CITY OF ALBUQUERQUE

May 9, 2022

Re: **Dia De Las Baristas**
1600 Eubank Blvd NE
Traffic Circulation Layout
Architect's Stamp 05-05-2022 (J21-D004A)

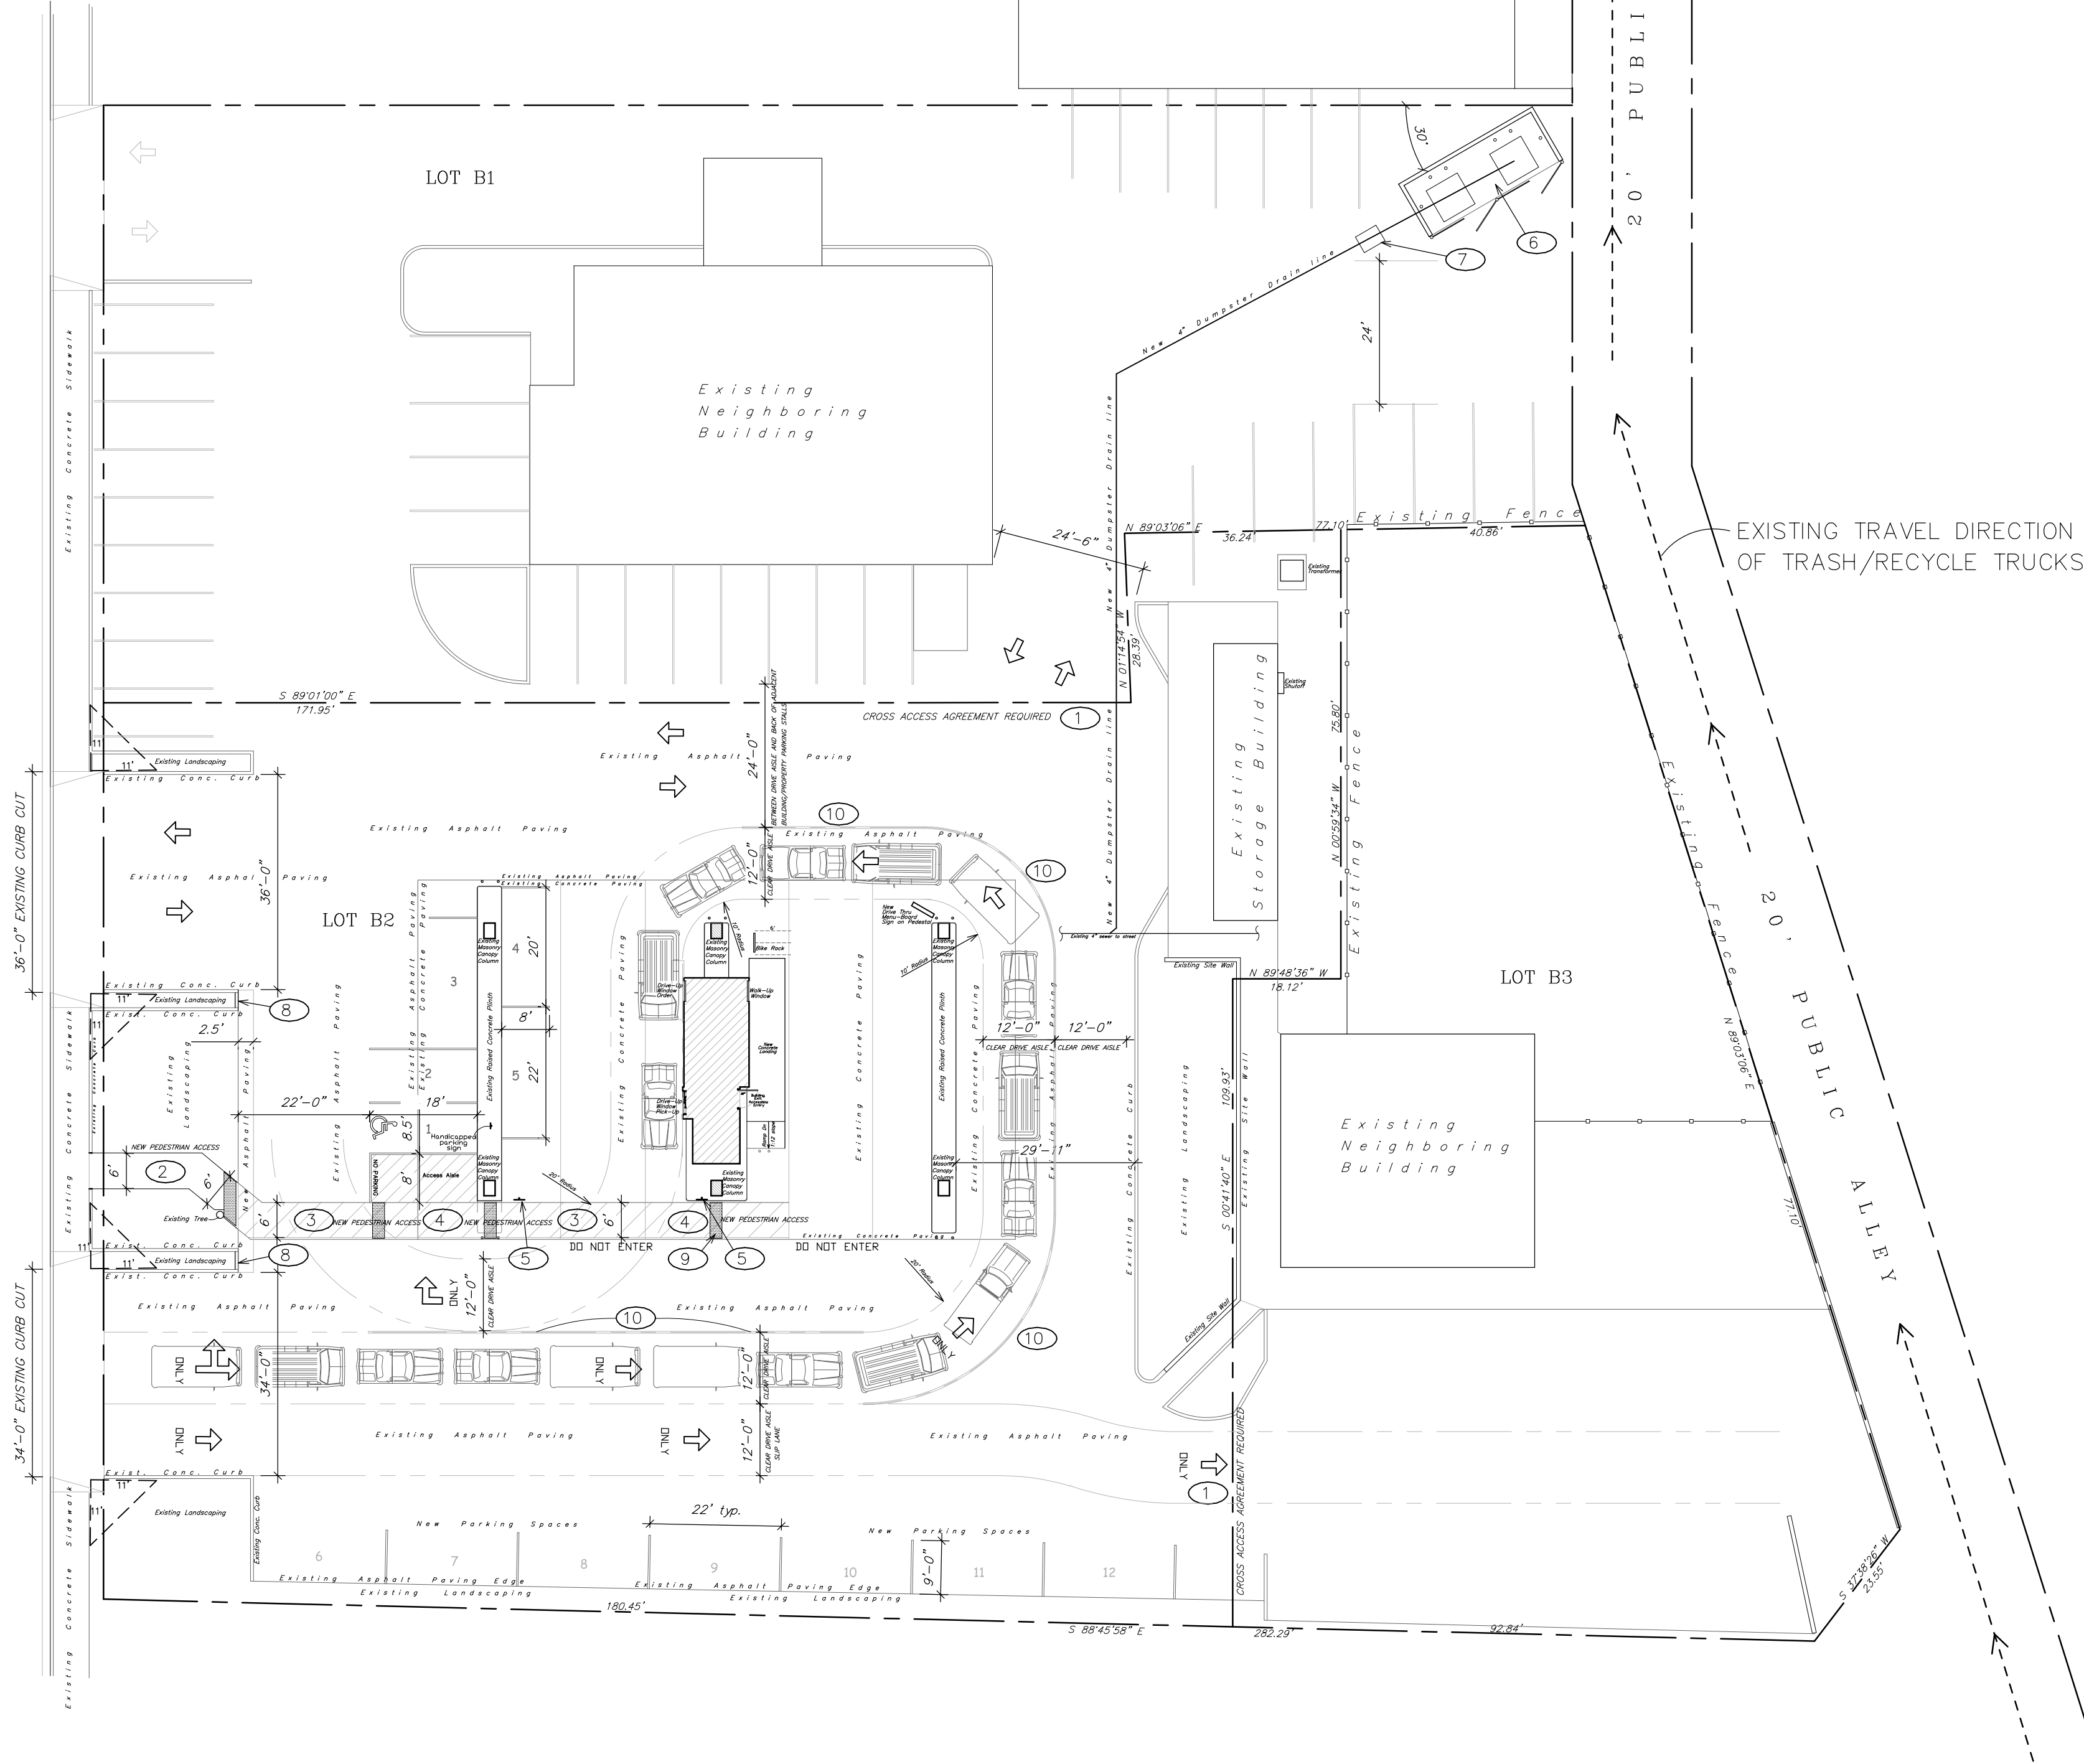
1. Listed are the number of parking spaces required by the IDO as well as the proposed number of parking spaces including bicycle and motorcycle parking.
Coordinate/discuss with Zoning.

2. A queuing analysis will need to be provided to ensure that proposed drive thru queue doesn't back into Eubank Blvd.
3. Please provide the total throat length at the 34ft Eubank entrance to ensure that it follows DPM Criteria [see 7.4(K)(15)].

4. **Keyed Note 1:** The Cross Access Agreement will need to be provided prior to TCL approval.
5. **Keyed Note 2:** Crusher fines will not be allowed only a hard surface will be acceptable for 6 ft ADA pedestrian pathway.

6. **Keyed Note 3 & 4:**
 - Provide striping detail for proposed 6 ft pathway across these pathway crossings.
 - You will need to provide some type of shielding/curbing across landscaping, parking stall, raised concrete island, and adjacent to building. Provide construction notes.

7. A scale of 1"=20' is recommended for sites less than 5 acres. What is the scale for proposed layout?
8. The ADA access aisles shall have the words "**NO PARKING**" in capital letters, each of which shall be at least one foot high and at least two inches wide, placed at the rear of the parking space so as to be close to where an adjacent vehicle's rear tire would be placed. (66-1-4.1.B NMSA 1978). **PROVIDE DETAILS OF PROPOSED TEXT.**

9. Eubank Existing 34 & 36 ft Entrances: The entrance ramp must be ADA curb ramps must be updated to current standards and have truncated domes installed. Please verify this condition.

10. You will need 12 ft exit lane out of site onto Eubank existing 34 ft entrance unless you are proposing this entrance to be only ingress and if this is the case then need to provide pavement markings and signage to enforce this traffic movement.

11. Adjacent to drive thru land you only have 12 ft of Clear Drive Aisle lane. So, where are the pavement markings and signage to define this traffic lane movement and it details for the markings and sign face?

12. Parallel parking adjacent to Raised Concrete Island and drive thru lane: What is the drive aisle width? And where are pavement markings/sugnage to define one way traffic aisle/lane?

13. **Motorcycle parking space:**
 - Why are you locating parking space so far from building site?
 - Provide detail for proposed pavement marking MC.
14. Show all drive aisle widths and radii. Some dimensions are not shown.

16. List radii for all curves shown; for passenger vehicles. Radius for delivery trucks, fire trucks, etc. is 25 ft. or larger.
17. ADA accessible pedestrian pathway should not be placed behind parking space or adjacent to a vehicular way. Vehicle and pedestrian/wheel chair conflicts should be avoided as much as possible.

18. Curbing should be installed to delineate landscape, parking, and pedestrian ways and identify points of access. Please call out detail and location of barrier curb.

19. Parking areas shall have barriers to prevent vehicles from extending.
20. Dumperster is located outside of lot limit. Please provide letter stating that it is okay to locate on adjacent property from owner of that property.

21. Fire Department: An approval Fire 1 plan needs to be provided.
22. All one-way drives shall have "One Way" and "Do Not Enter" signage and pavement markings. **Please show detail and location of posted signs, sign face detail and striping.**

23. All proposed striping, pavement markings will need details provided.
24. The minimum drive through lane width is 12 feet with a 25 foot minimum radius (inside edge) for all turns. (A 15 foot radius can be used with an increase in lane width to 14 feet). Please dimension all lane widths and radii.
